From: Elizabeth Downing <Elizabeth.Downing@shoalhaven.nsw.gov.au>
Sent: Friday, 2 March 2018 11:09 AM
To: Michelle Niles
Cc: Natasha Harras; Anthony Witherdin
Subject: RE: Notification of Modification Request - MP 05_0024 MOD 4, Dolphin Point (3A07/1004)

Please be advised that Allen Price & Scarratts Pty Ltd on behalf of Malbec Dolphin Point Pty Ltd (the Proponent) has submitted a Modification Request to modify MP 05_0024 MOD 4 for a residential subdivision at Lots 117 and 118 DP 1226471, Highview Drive, Dolphin Point.

Ref. No.		<b>24163-21</b>	
1	OF 1	SHEETS	11

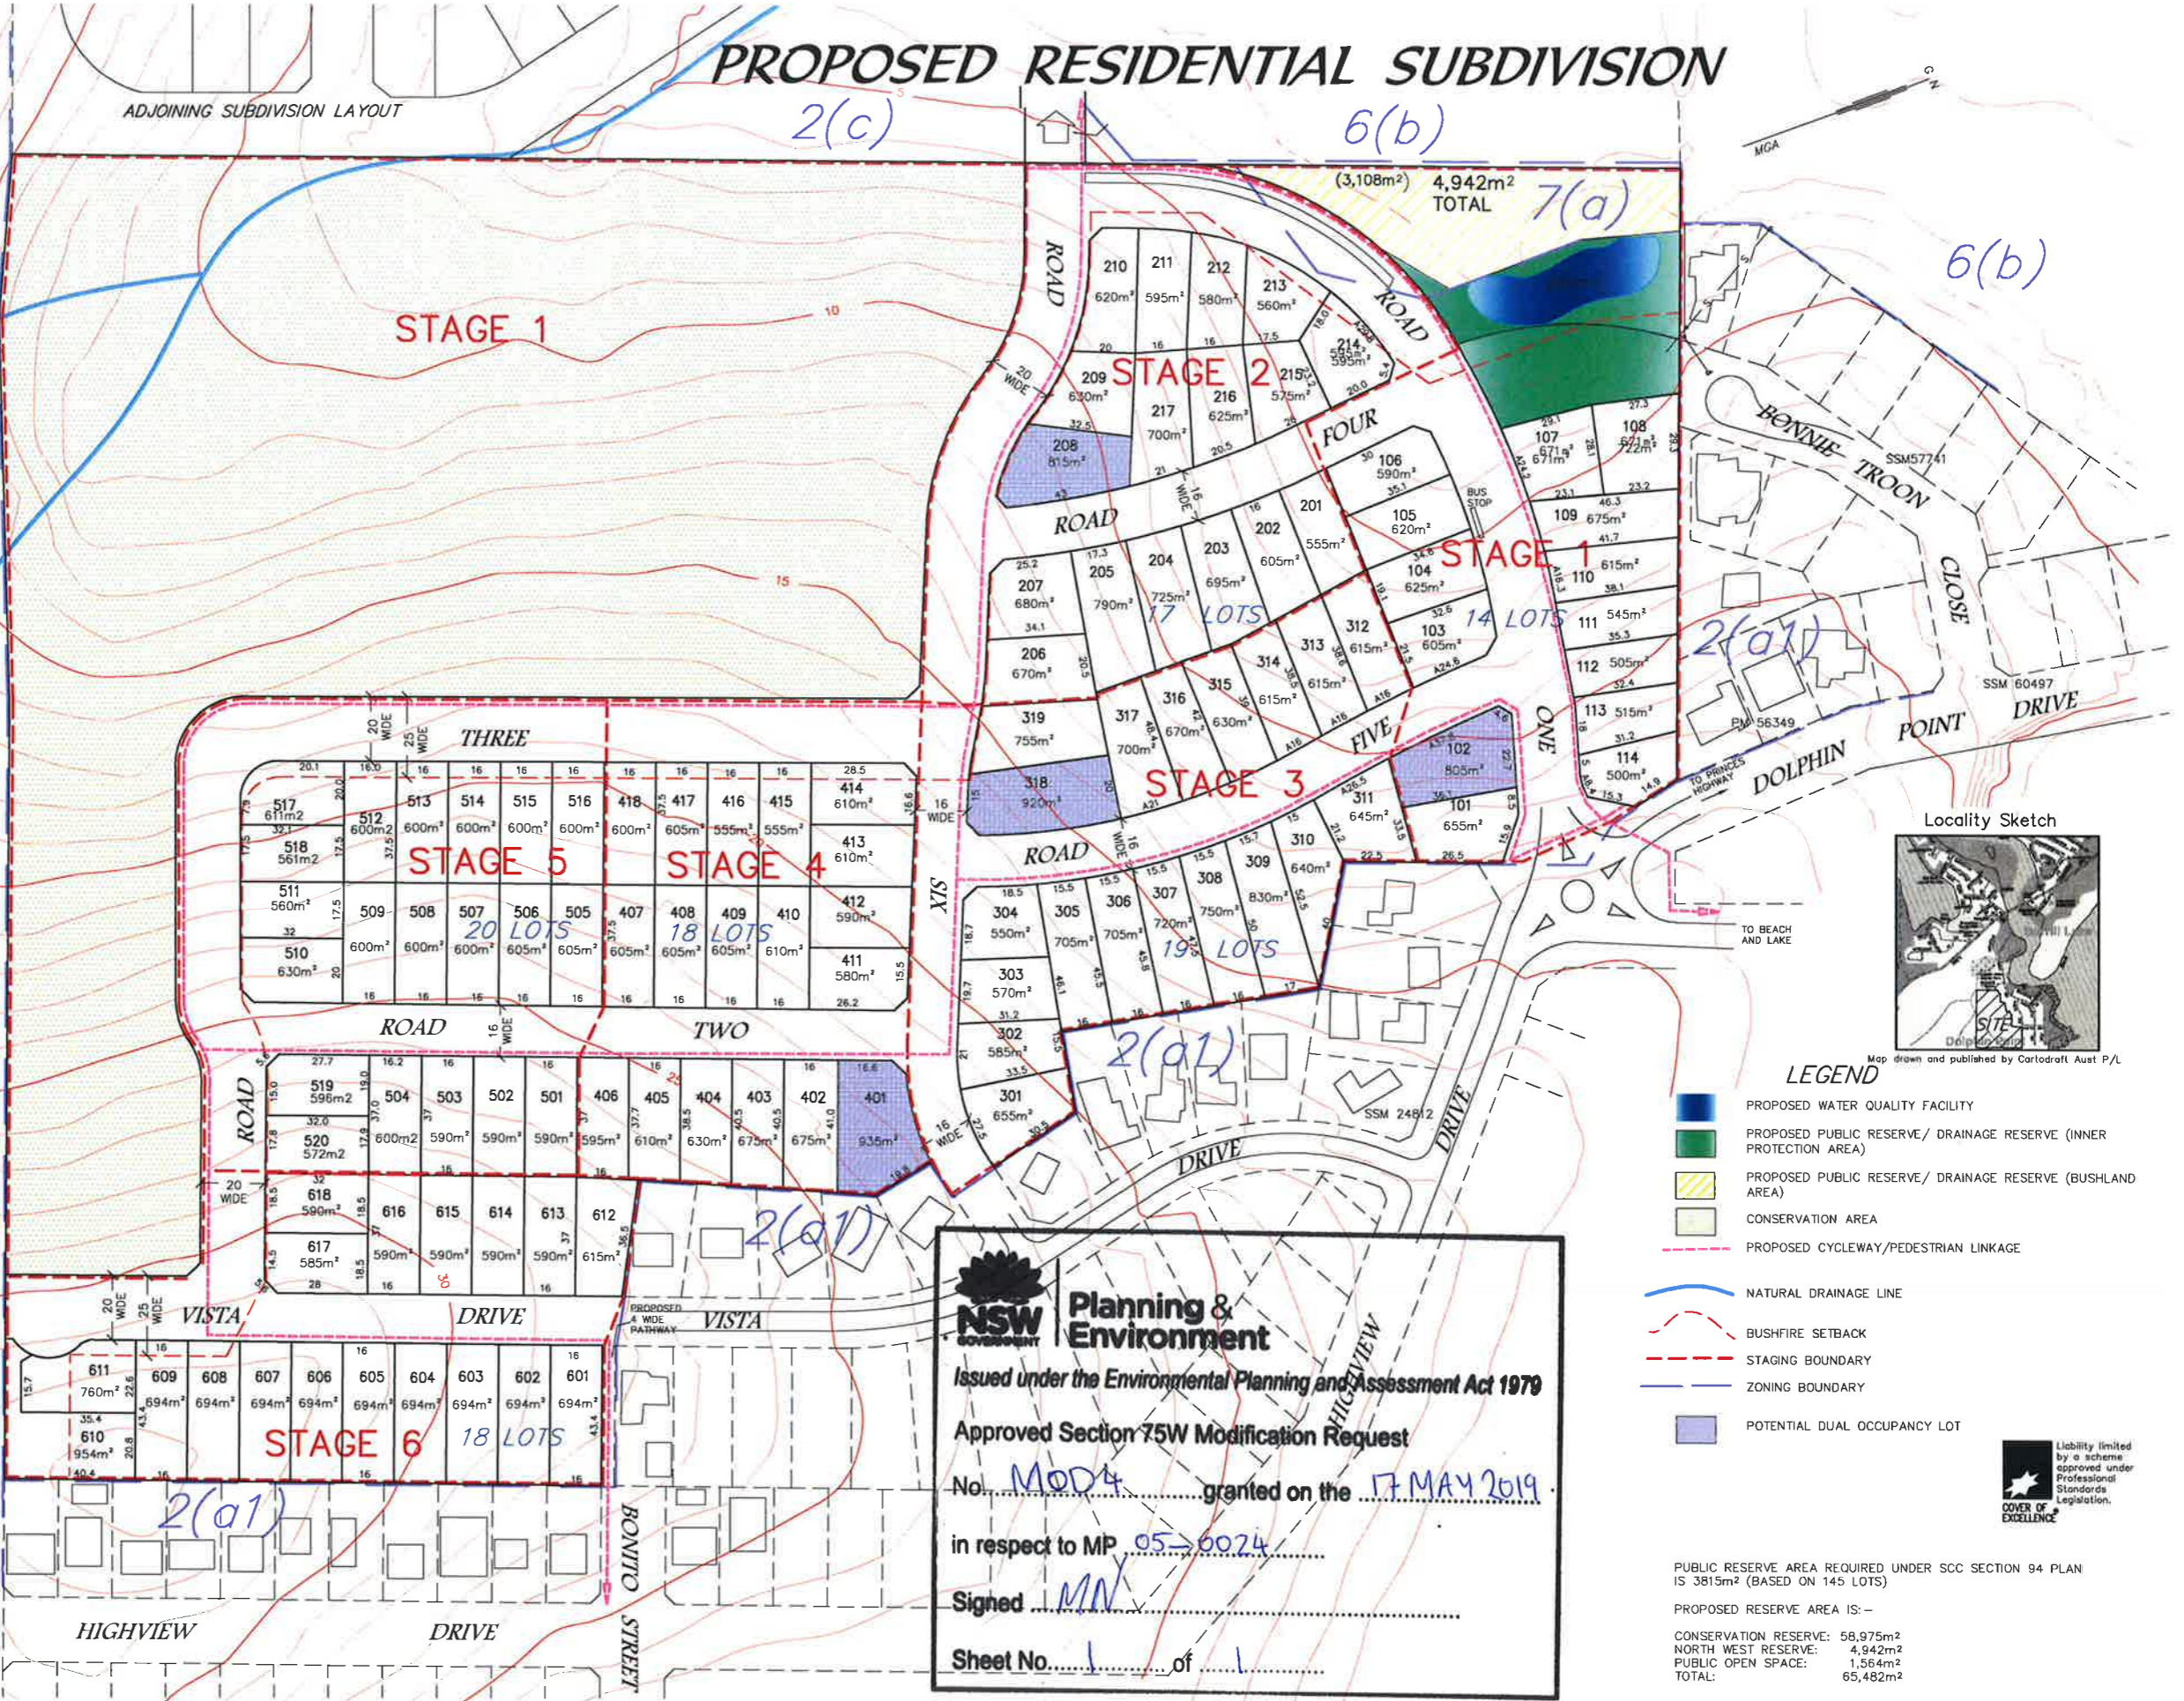
Council's traffic unit partly support the revision noting the changes between revision 02 and revision 09 in road layout. However the condition for providing an appropriate LATM treatment on Vista Drive south of Bonito Street should remain to discourage through traffic and maintain a low speed environment.

~~The developer will construct footpaths as shown on Drawing 24163-21 Rev 2 prepared by Allen Price and Associates.~~
The developer will construct footpaths as generally shown on drawings 24163-21 Revision 09 dated 20/07/17 prepared by Allen Price and Scarratts and approved Construction Certificate Drawings.

~~The developer will construct traffic calming facilities in the locations shown on drawing 24163-21 Revision 2 prepared by Allen Price and Associates.~~
The developer will construct traffic calming facilities in the locations shown on drawing 24163-21 Revision 09 dated 20/07/17 prepared by Allen Price and Scarratts.

Traffic unit partly support the amendment, however the LATM device on Vista Drive south of Bonito Street should remain, as referred to previously.

Traffic unit support the amendment
